From: Roxanne Navrides <toroxanne@outlook.com>
Sent: Thursday, March 16, 2023 7:39 PM
To: Sarah Fletcher; Ryan Harriman
Cc: Suzanne Skone; Dan Thompson; Mike or Susie Cero; Carv Zwingle; Thomas Acker; Council; Traci Granbois; Robert Medved; Jessi Bon
Subject: Re: Public Comments SUB 19-002/Boys and Girls Club Long Subdivision

Dear Ryan, I am a long-time resident of Mercer Island, and have been involved in this subdivision since the property was originally purchased from the Boys and Girls Club, a very unfortunate situation. The purchasers never honored their promise to build and provide ballfields for Island youth and the city never required a deed on the property despite the fact the Boys and Girls Club, city, and private citizens spent several million dollars to build Peak rather than buy this parcel for roughly the same price. Many citizens, and council members, felt deceived.

The two key concerns I have are:

2/16/23
 JOB NUMBER:
13-118
 SHEET NAME:
SP-01
 SHT **3** OF **9**

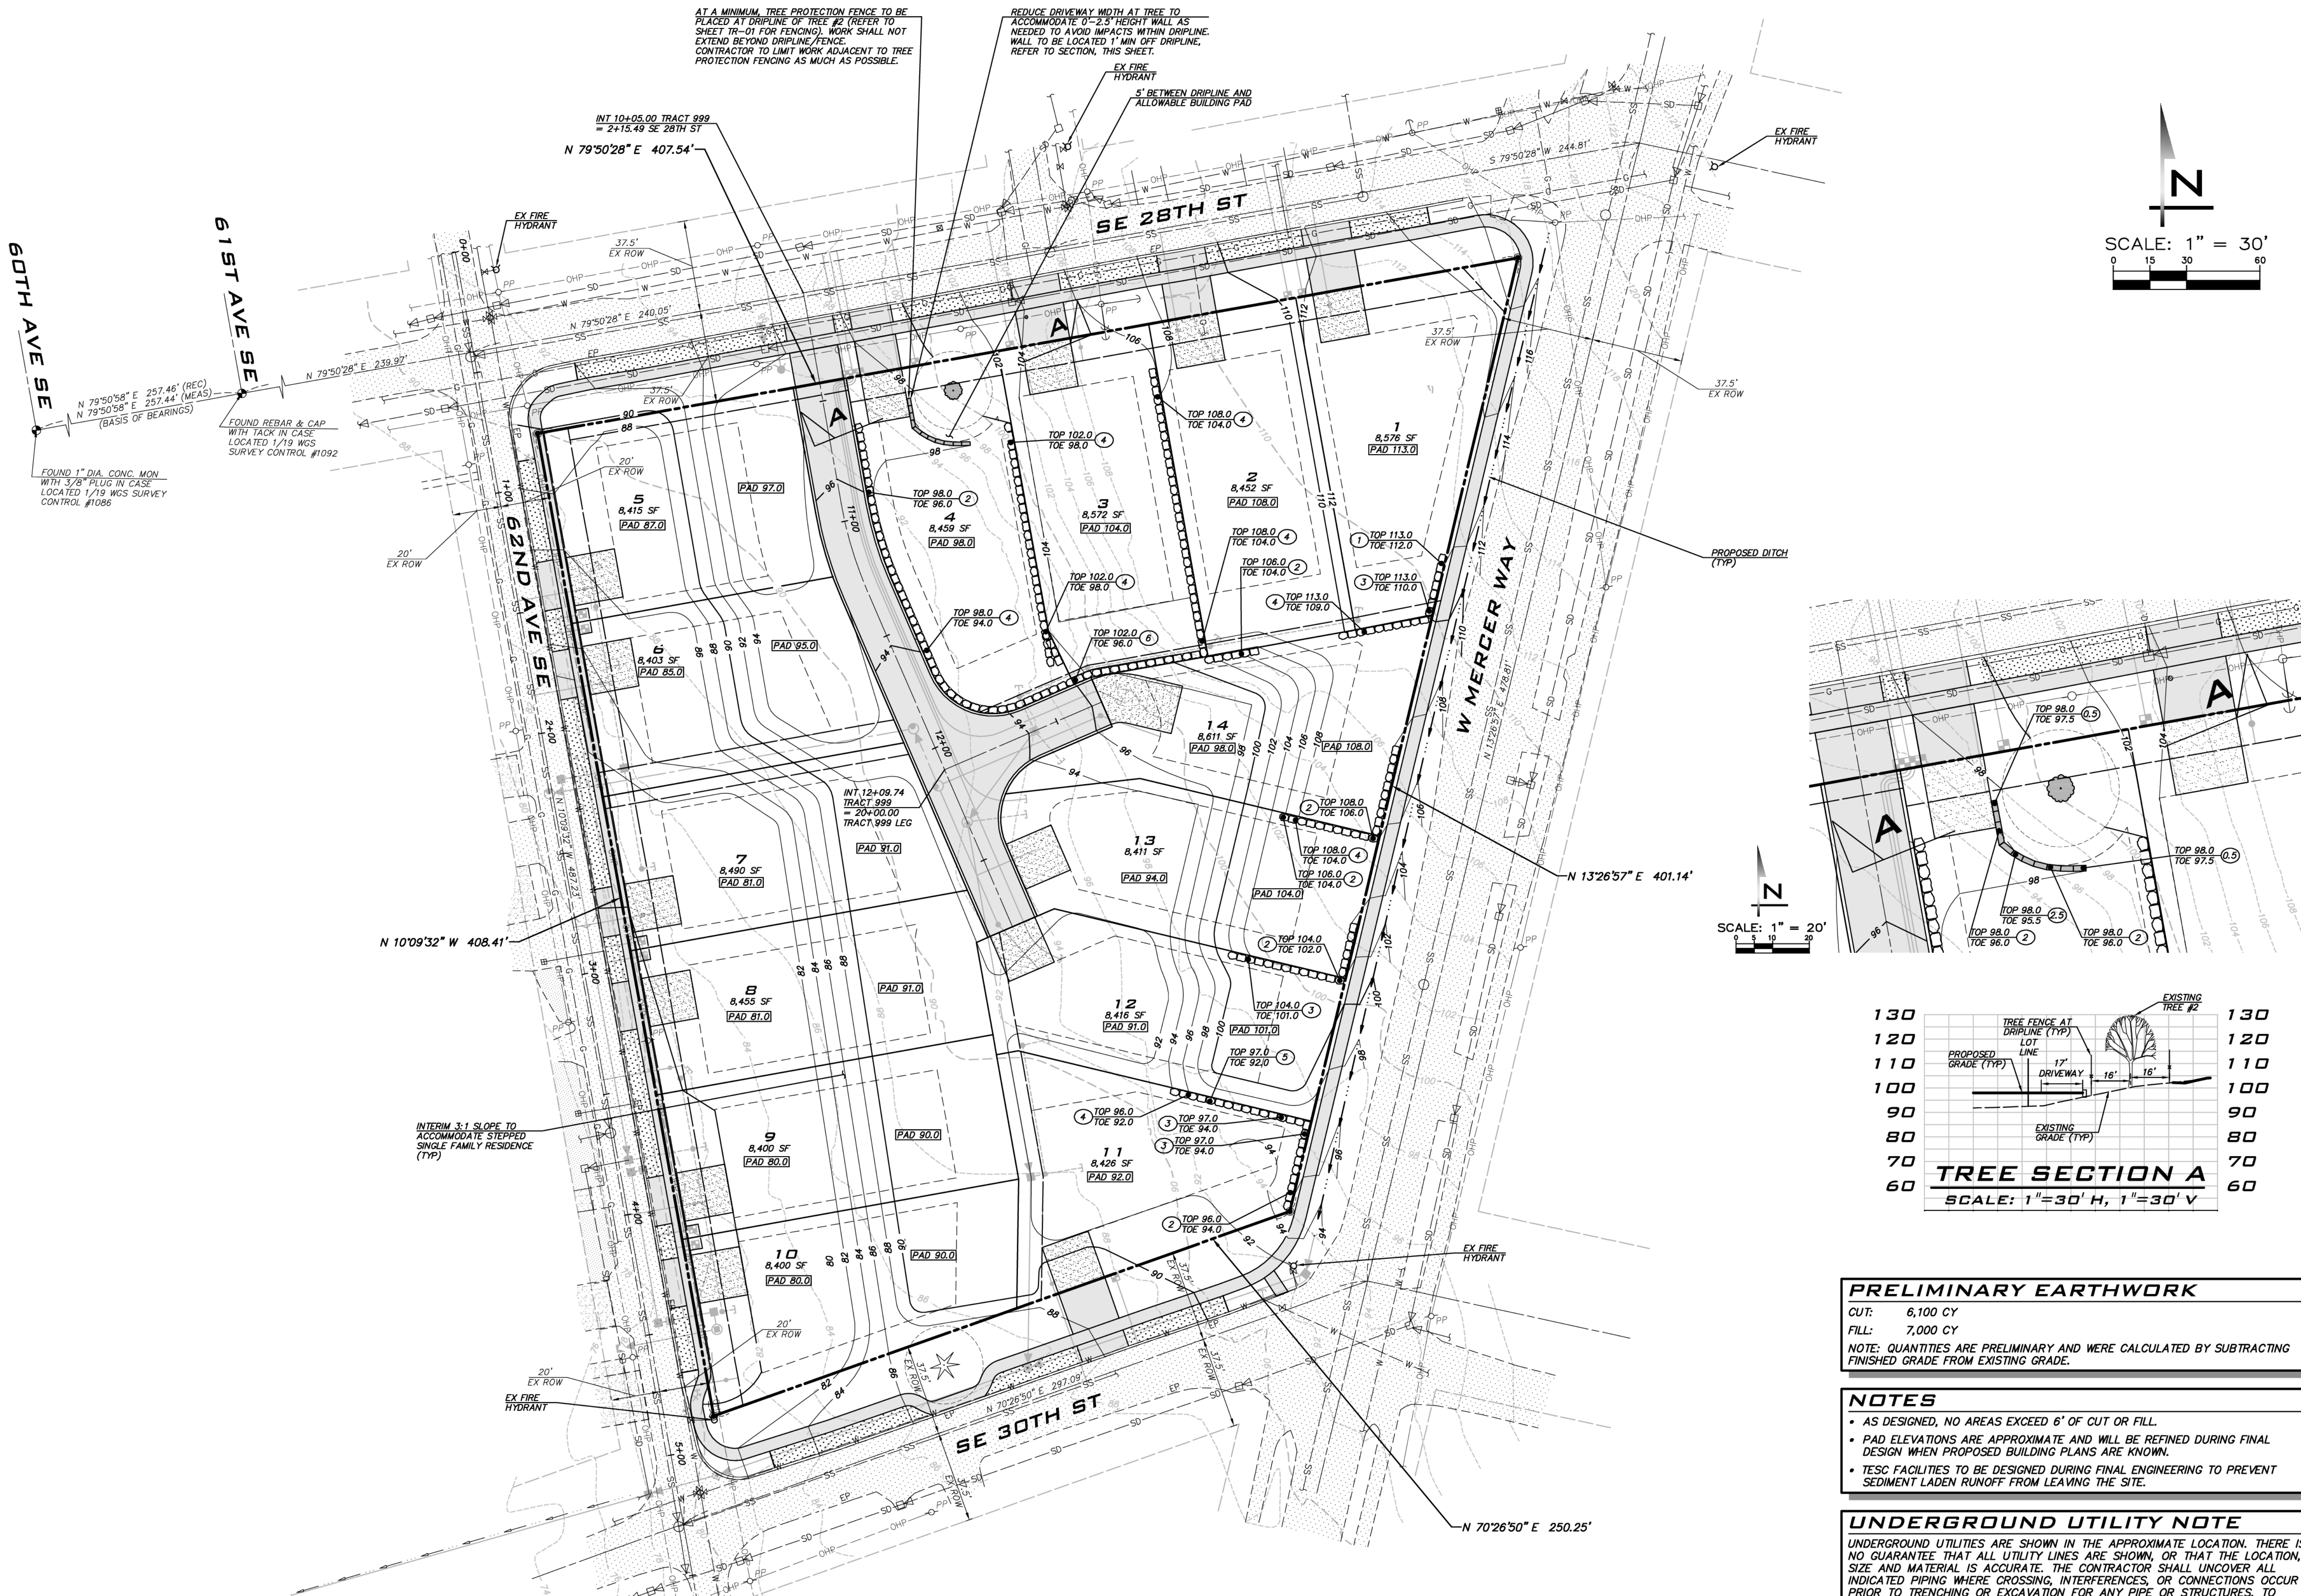
A. There is no green space at all, despite the demolition of an historical building and removal of many mature trees. I believe some green space setaside should be required as in the original plans although it reduced the total number of lots from 14 to 13.

B. Ingress and egress should be by internal road for each house. The applicant no doubt does not like this since the internal road counts against lot area and lot coverage limits, but in my opinion the current plans are a danger to those walking or biking along adjacent streets. There is some internal access to some lots, but all access should be by an internal access road.

My belief is the MICC requires the applicant to set aside an area equal to one lot for green space, and all access should be by internal roads. These are the same findings Evan Maxim made if you review his file, and were the findings of the council in the Coval long plat process.
